***COLLEGE OF FINE ARTS (COFA)
REDEVELOPMENT, PADDINGTON***

***Proposed by Hindmarsh Construction
Australia***

MP 08_0104 (MOD 3)

Modification of Minister's Approval under section 75W
of the *Environmental Planning and Assessment Act*
1979

project COFA Gateway  
drawing MAJOR CHANGES - BLOCK F - SOUTH & NORTH ELEVATIONS  
drawing no. A7-04 issue A  
9/02/2011 5:49:42 PM

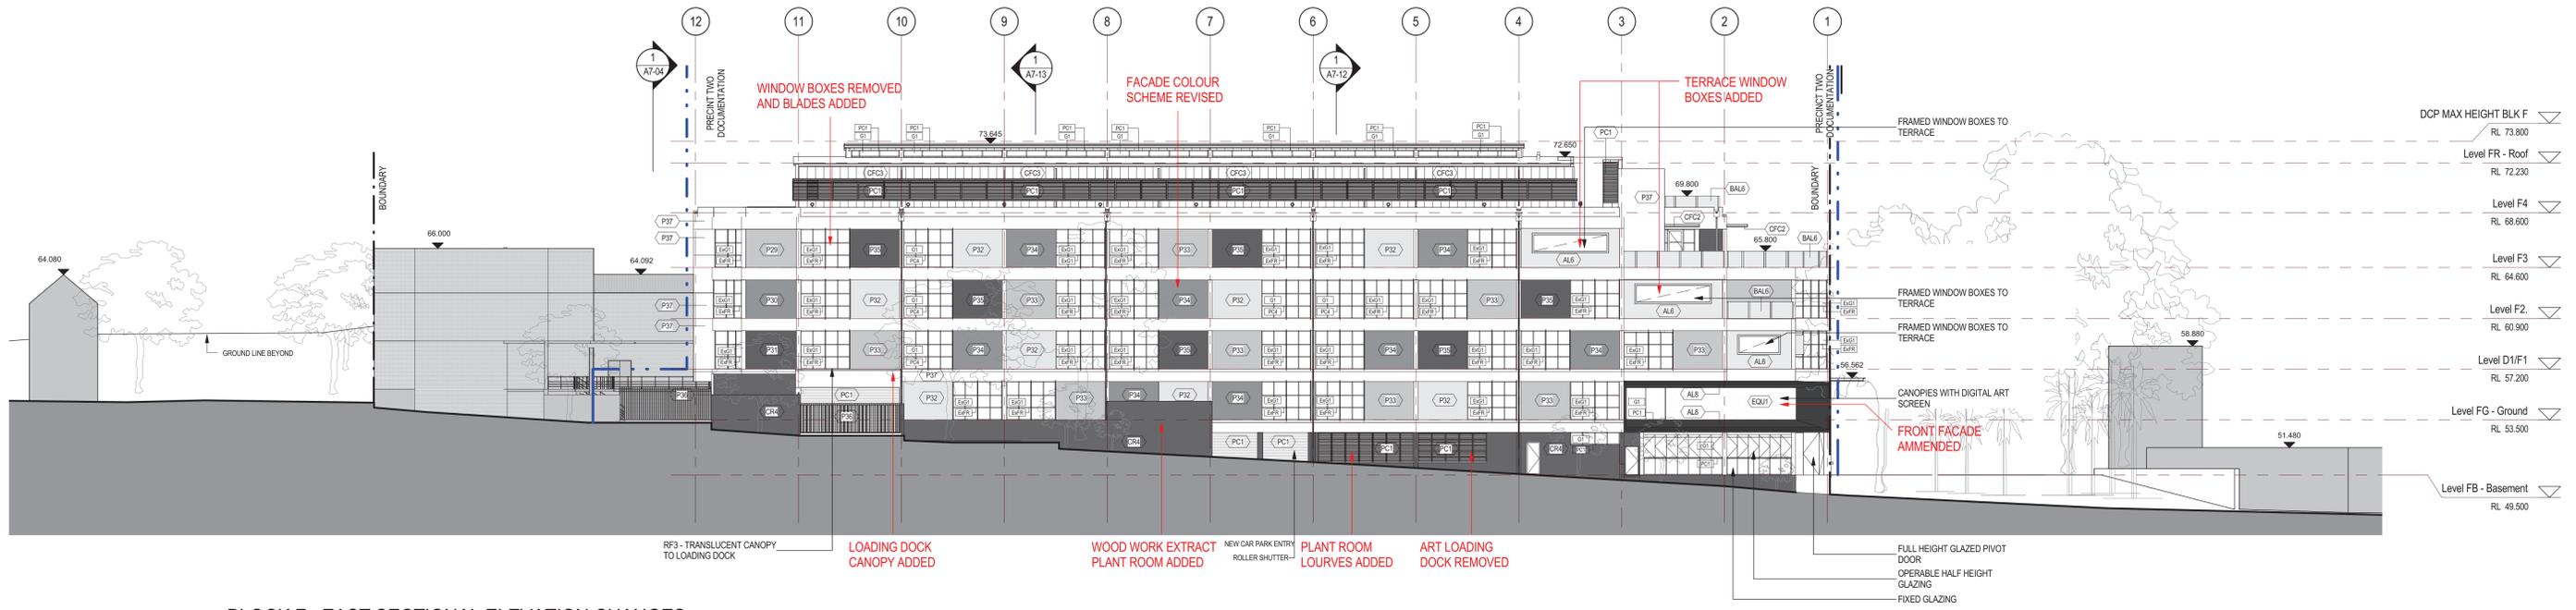
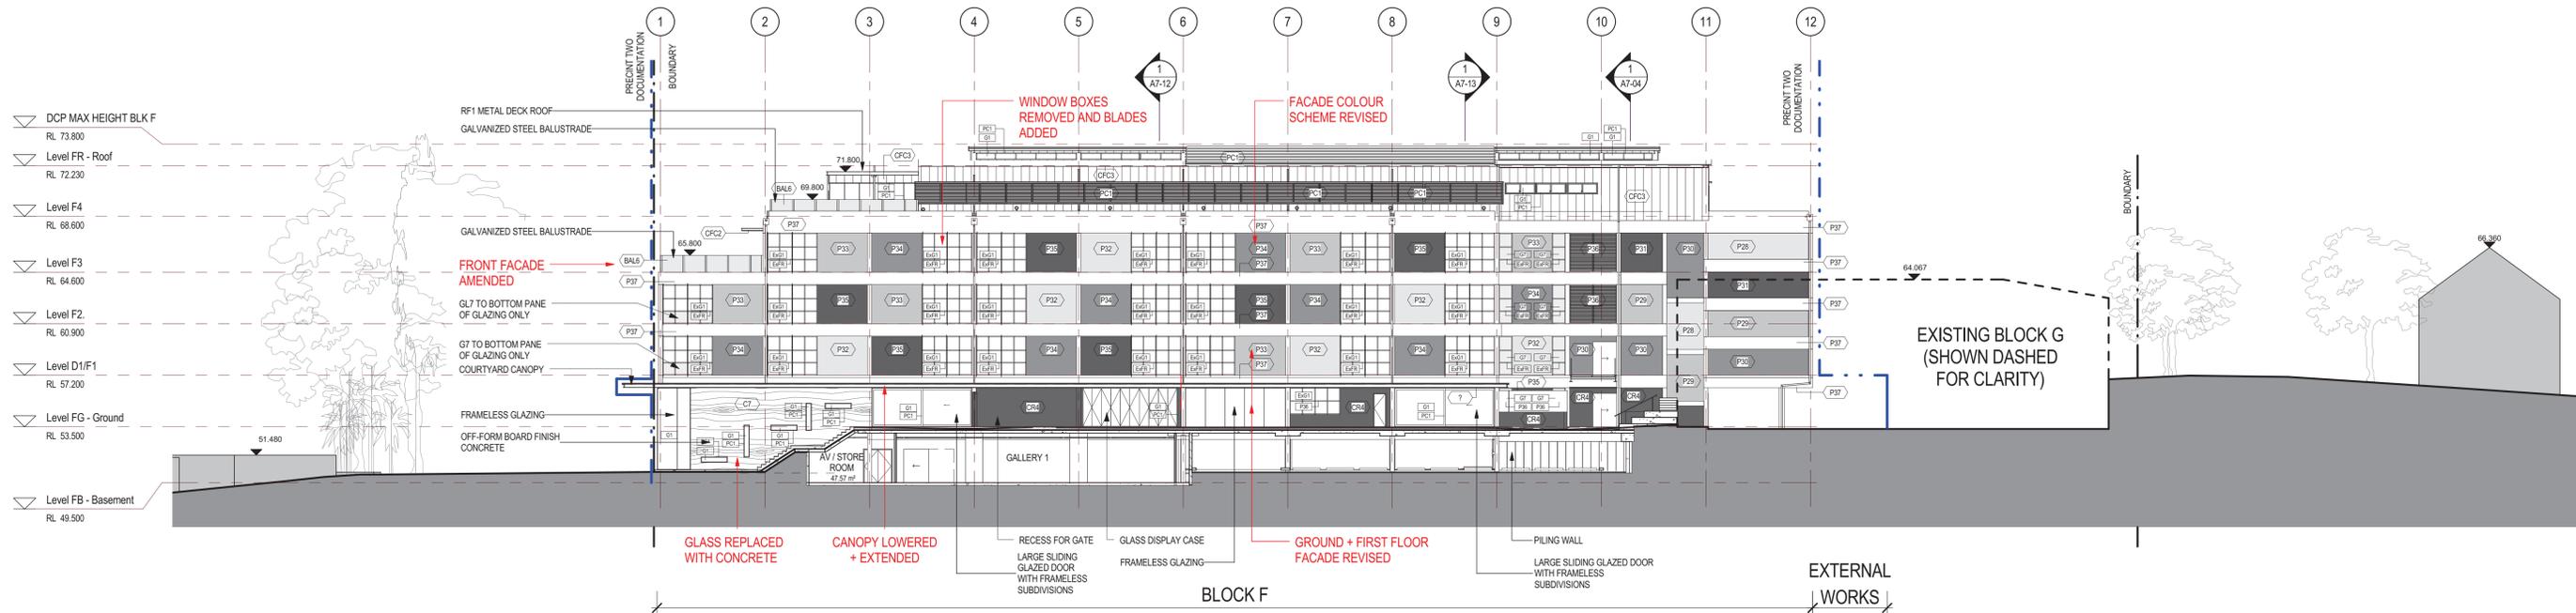
- the plans and images submitted with the application are insufficient to fully address the impact of the changes to the north facing elevation of Building F and how it addresses Napier and Oxford Streets;
- the opportunity to provide an iconic building that provides open and active ground floor uses to Napier Street will be lost; and

- the proposed wrap around digital screen is considered inappropriate for the site and location.

The Department notes that the canopy at the north east corner slightly overhangs the splayed corner boundary. This is considered acceptable as it is in-keeping with shop front design character in the area and also reinforces the corner element of the building.

The part of the Napier Street frontage occupied by the entry foyer façade further to the west of the café space is however proposed to be provided with a visually solid concrete finish in place of the approved glazing. The Department considers this visually solid element is acceptable as it only forms a small portion of the Napier Street frontage. Further, the foyer space as approved does not provide an activated street front to Napier Street. The Department considers this aspect of the proposed modification to be acceptable as the approved café will maintain an active street front for the building.

On 21 July 2011, Council advised the Department that after having reviewed the additional information submitted by the Proponent, it supports the proposed modifications.

Noting the above points and the assessment of the SEPP 64 criteria, the Department considers that the proposed screen meets the aims and objectives of SEPP 64 and is appropriate for the site and locality, subject to conditions relating to the hours of use and content of the screen.
